From: Clay Barnett
Sent: Friday, June 05, 2009 10:57 AM
To: Carmen Moran
Cc: Nancy Cline
Subject: Beltwood North Plat Comments

I reviewed the plat for Beltwood North. The only comment I have is as follows:

**FINAL PLAT**  
REPLAT OF LOT 2, BLOCK A  
BELTWOOD NORTH - AIRPORT ADDITION  
TOWN OF ADDISON  
LOCATED IN THE GEORGE SYMS SURVEY,  
ABSTRACT NO. 1344, DALLAS COUNTY, TEXAS

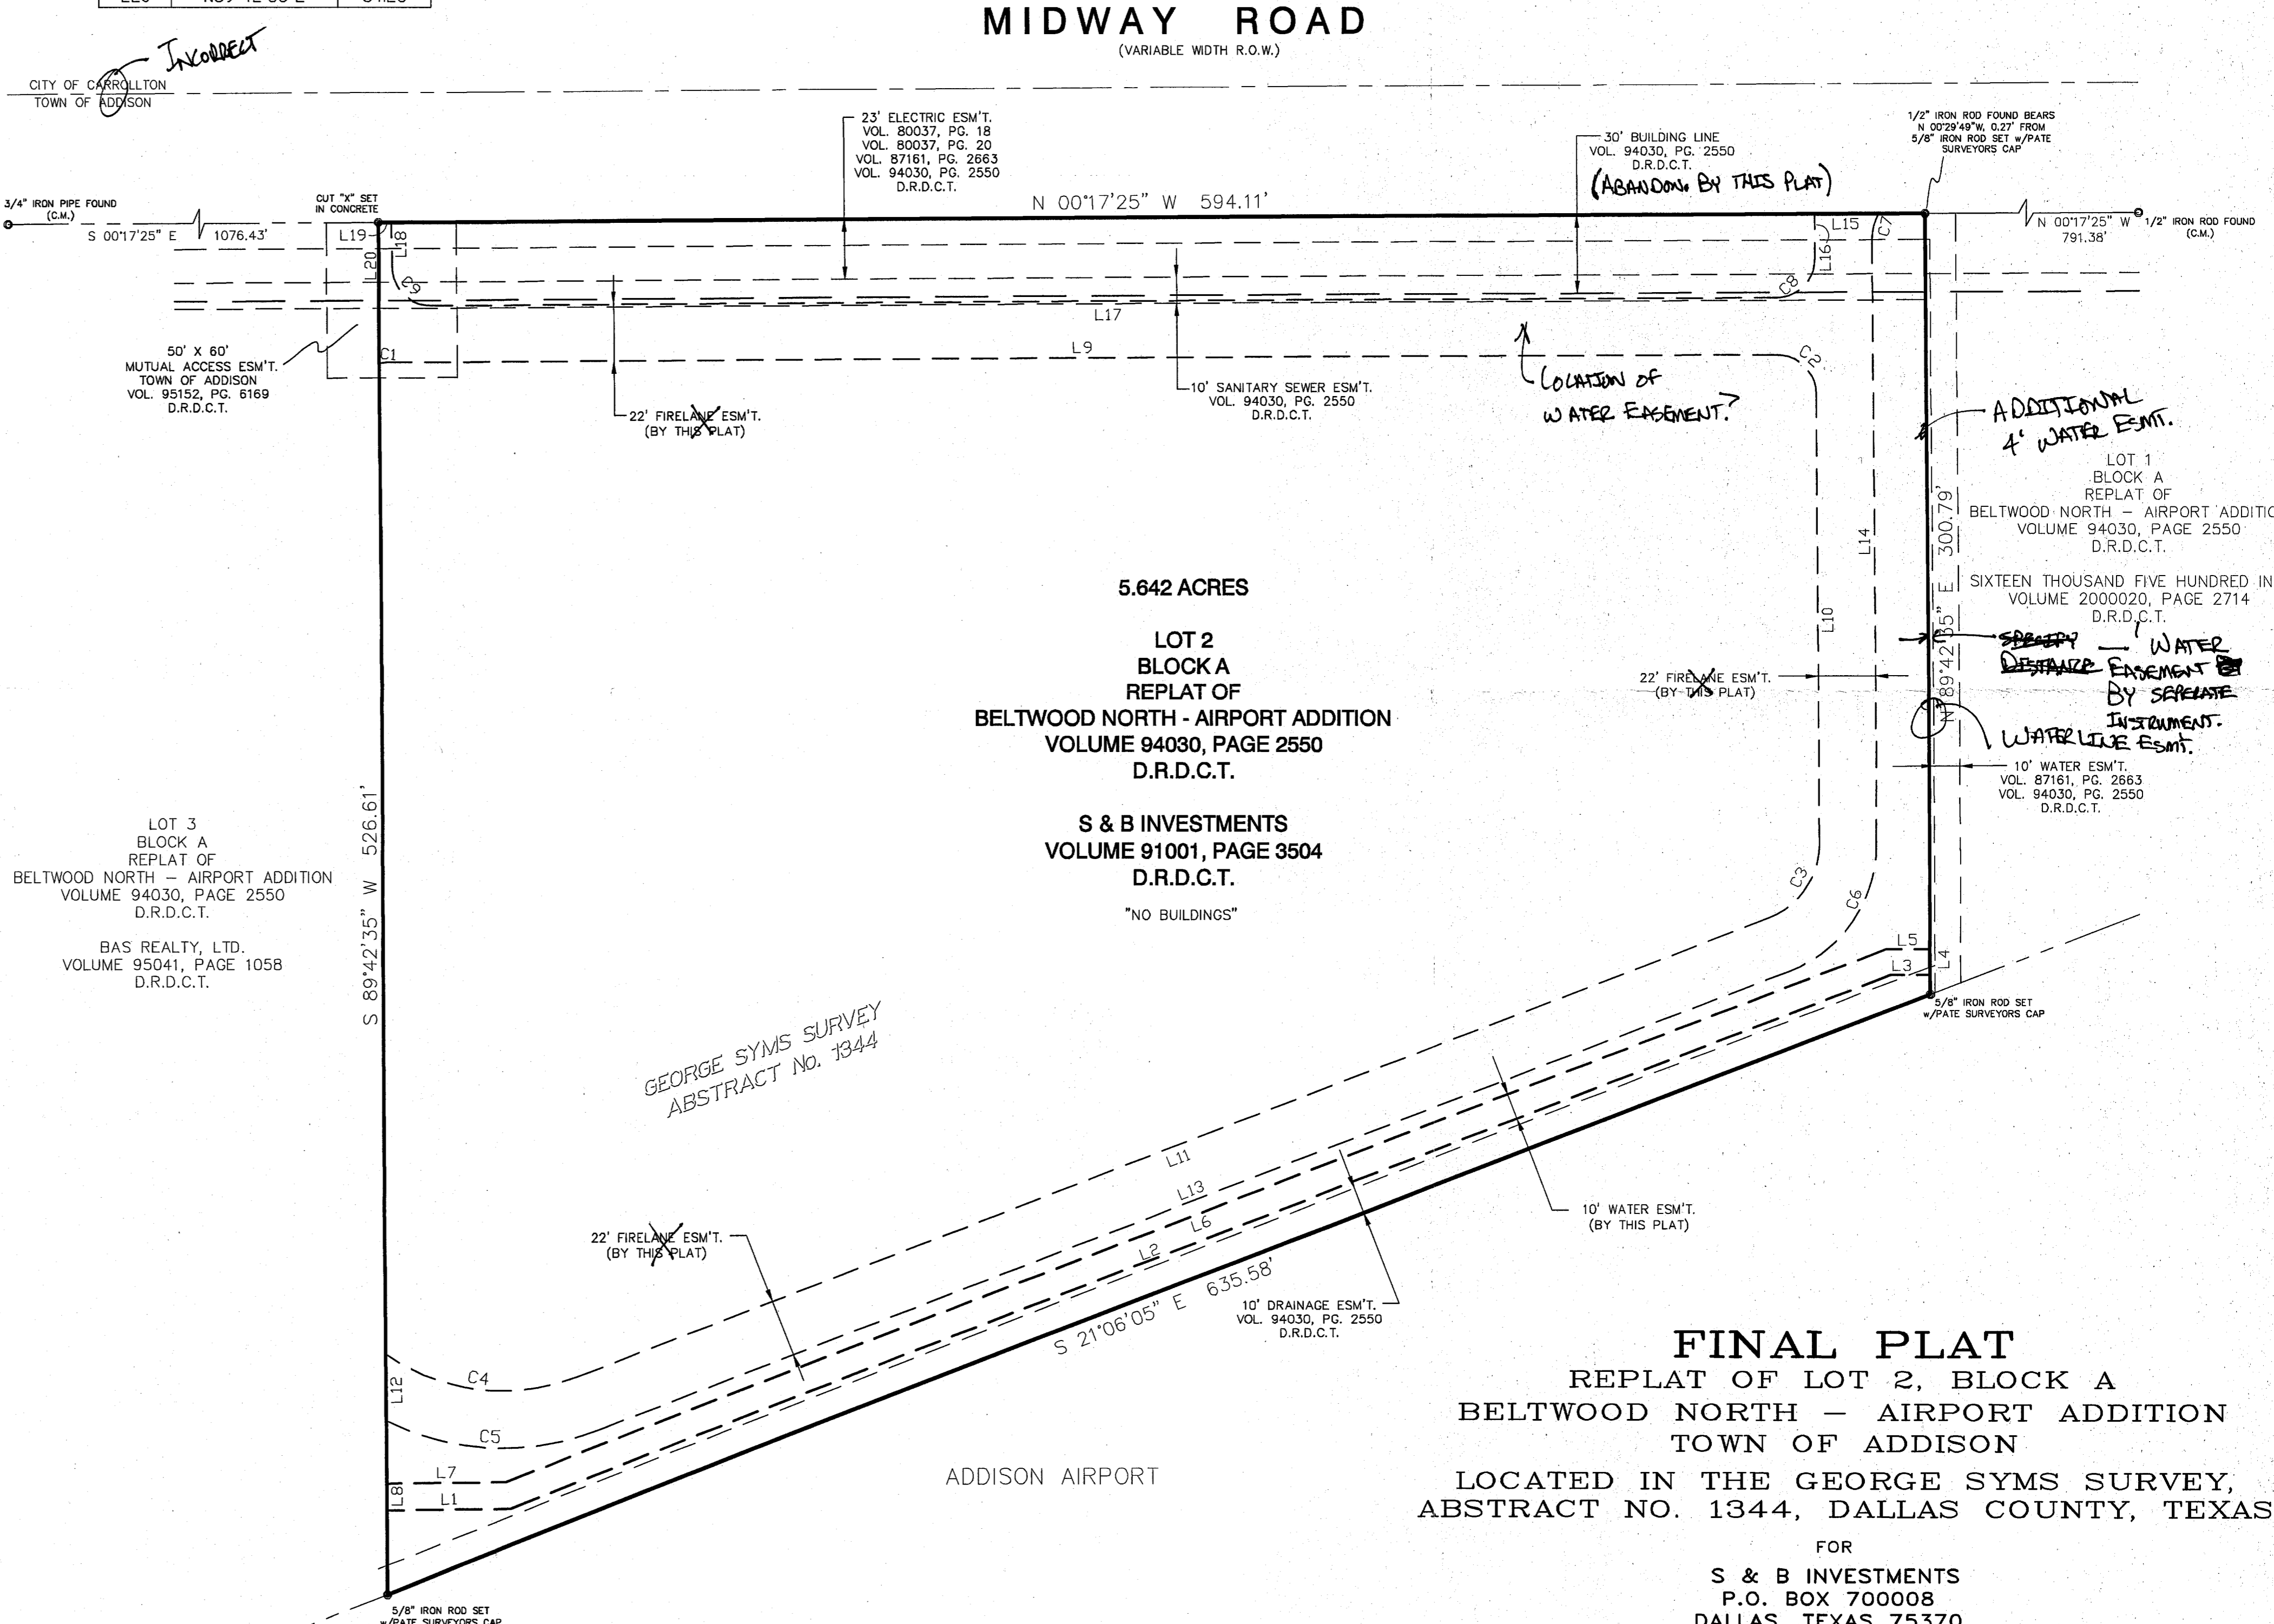
Remove the temporary offsite construction easement from the adjacent property to the north that is not included within the limits of the platted property.
